## SUBMISSION 2: SUMMARY OF ADDITIONAL CONCERNS IN RELATION TO THE PROPOSED NORTHCONNEX TUNNEL

Application number - SSI 13\_6136

**This is an objection to many aspects of the proposed NorthConnex tunnel.**

MOTORWAY OPERATIONS COMPLEX - SOUTHERN VENTILATION FACILITY - SITE SECTION 1-1
M1-M2-5000-DR-UD-0713

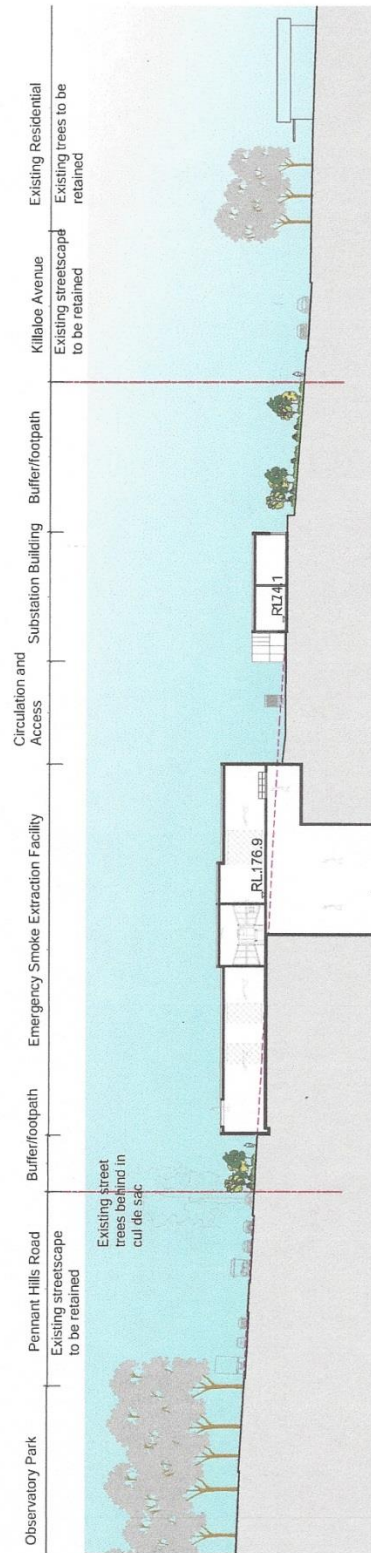
Speakers at the NorthConnex Air Quality Forum spoke of the importance of the topography in the placement of the ventilation facilities. In the NorthConnex proposal the southern ventilation facility is at the lowest point of the M2 intersection where it is surrounded on three sides by hillside cuttings. In this location the “discharge point” will barely be above the adjacent high ground.

Much is made of the intention to discharge the polluted air through the stack at 13 – 19m/s. Given that the stack is only 15m above Pennant Hills Road, a simple calculation indicates that the particles will be ejected to a height of between 23m and 33m above Pennant Hills Road. That will only be sufficient for them to be dispersed by prevailing winds IF there is wind and it is strong enough. For instance, the weather history graph showing the wind speed and direction at West Pennant Hills measured on the 24th August 2014 indicated that there was no wind until 9am and what wind there was, came from the west. Wind speeds of less than 2m/sec (ie about 8km/hour) are not considered sufficient to disperse pollution from the stack. Only a very few gusts on this day were in excess of 8km/hour.

That the Government ensures that the southbound ventilation facility ie the Stack, be located at the south-west corner, on the RMS owned land, at the edge of the Pennant Hills Golf course. In this location, the southbound tunnel can be efficiently, effectively and economically ventilated.

The impact of the stack plumes on the surrounding residential areas must be modelled using its current proposed position and height and also modelled with the stack positioned on the golf course side of Pennant Hills Road, where it is topographically higher. This would allow an objective, impartial, scientifically based assessment to be made of the most effective location for the stack.
